Nature's Cross Roads

**Re: Status of Improvement Permit Application #06-5-15911 Lt 3
#06-5-15912 Lt 6**

• Pine Grove Dev. Corp.
• Lot # 6 Nature's Cross Road
OG-500-15912

SURVEY FOR: LOT #6

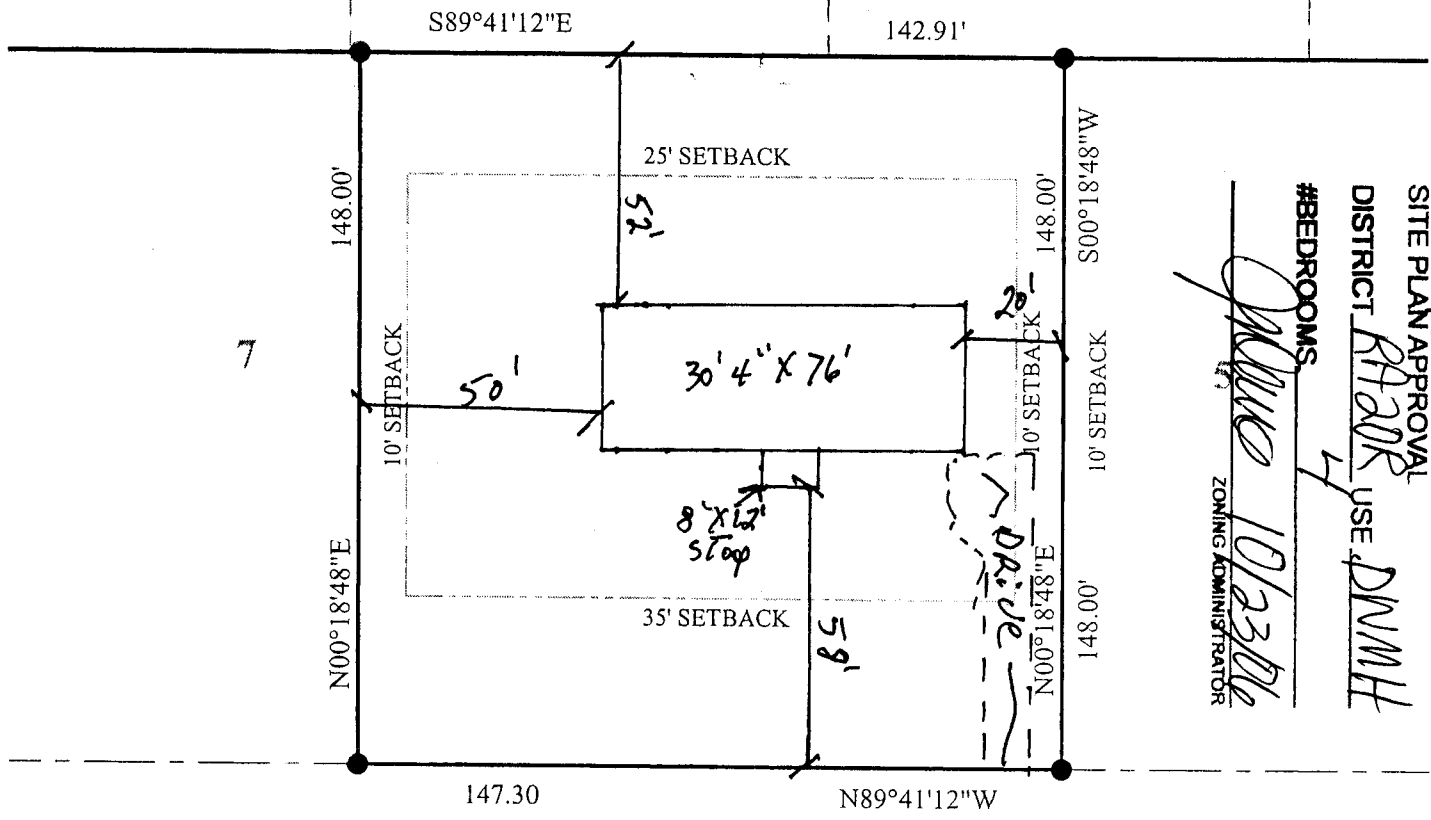
- 1. Property lines/corners not marked or labeled
- 2. House corners not marked or labeled
- 3. Directions not clear to property
- 4. Property needs brush or vegetation removed
- 5. Backhoe pits required
- 6. Other – Move house site as shown on attached sheets. Resubmit new plot plans to Central Permitting.
